ELK RIDGE ESTATES

A SUBDIVISION OF A PORTION OF THE SOUTHEAST ONE-QUARTER
OF SECTION 23, T 12 S, R 66 W OF THE 6th P.M.,
EL PASO COUNTY, COLORADO

PAGE 1 OF 3
JOB NO.: 43116
AUGUST 25, 2026
EL PASO COUNTY PLANNING FILE NUMBER: SF266

JOB NO.: 43116  
OCTOBER 1, 2026  
PAGE 2 OF 3

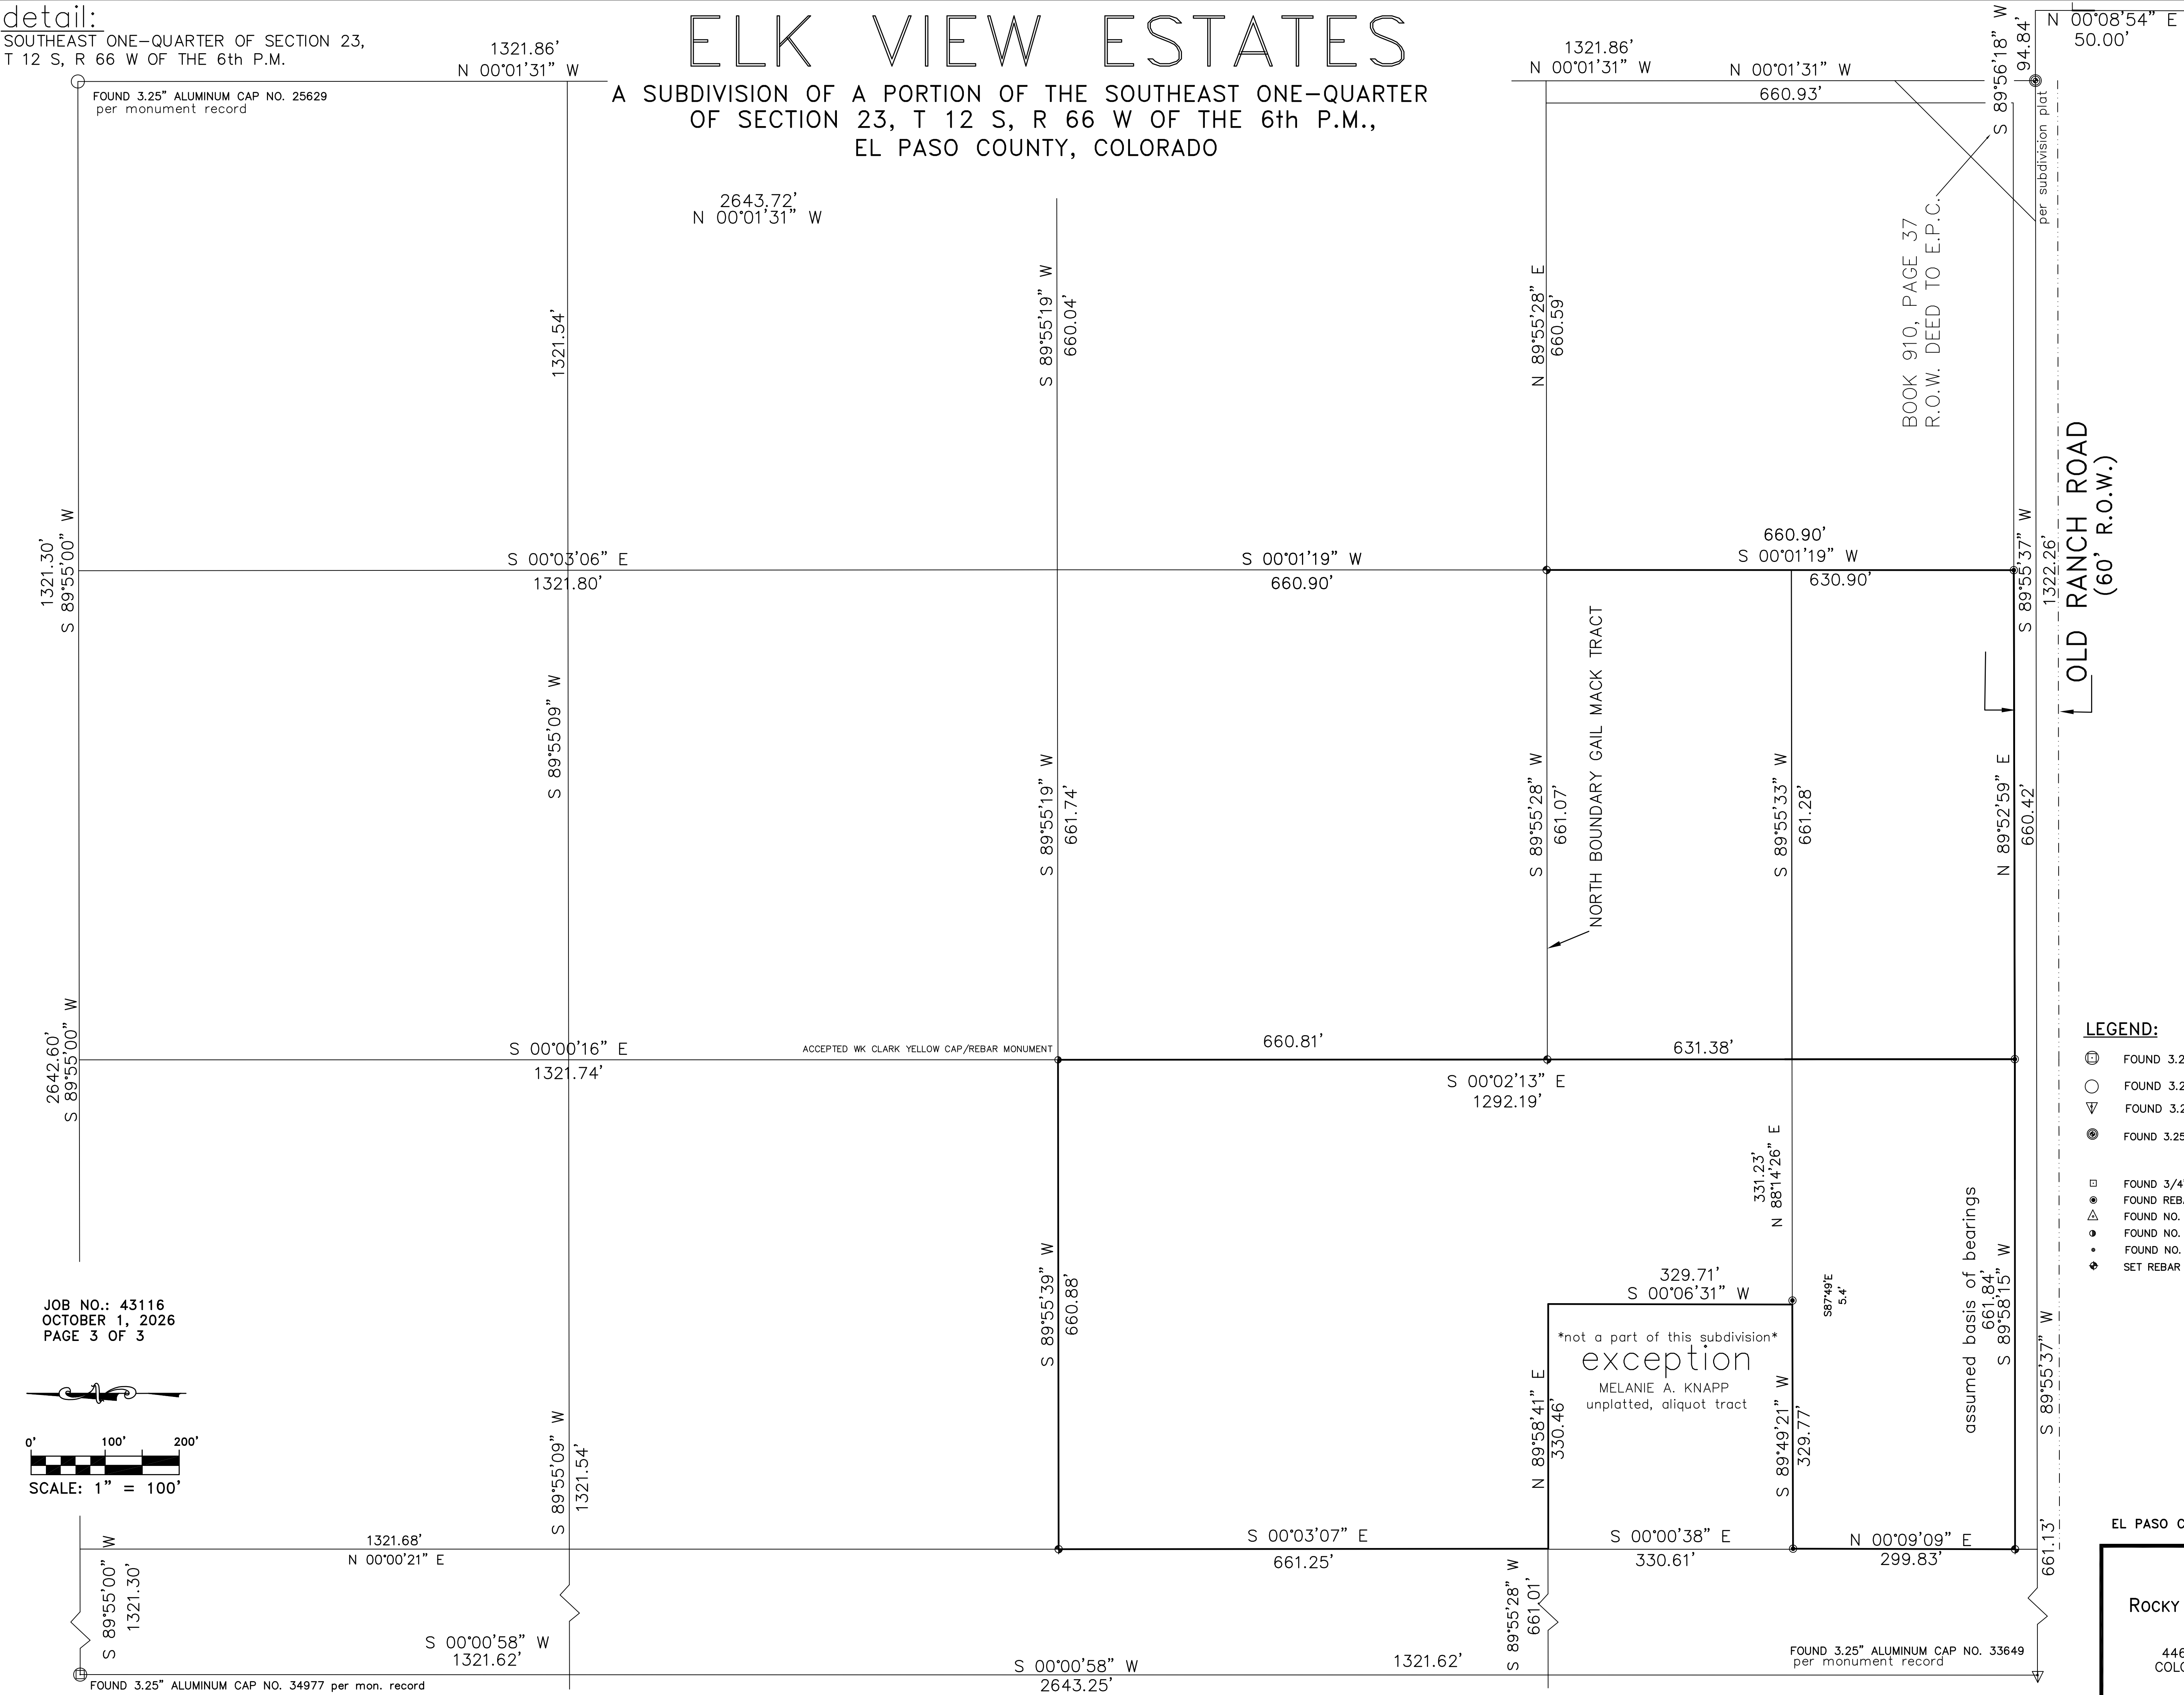
Is it the intention of
the applicant to utilize
this easement for the
roadway? If so,
please discuss in the
Letter of Intent.

Please contact E911 for a new name for this street pursuant to their review comments copied and pasted below for your convenience:

Elk Heights - Not available, existing.

For clarification, the streetname must be unique. Taking an existing streetname and
changing the suffix is not sufficient.
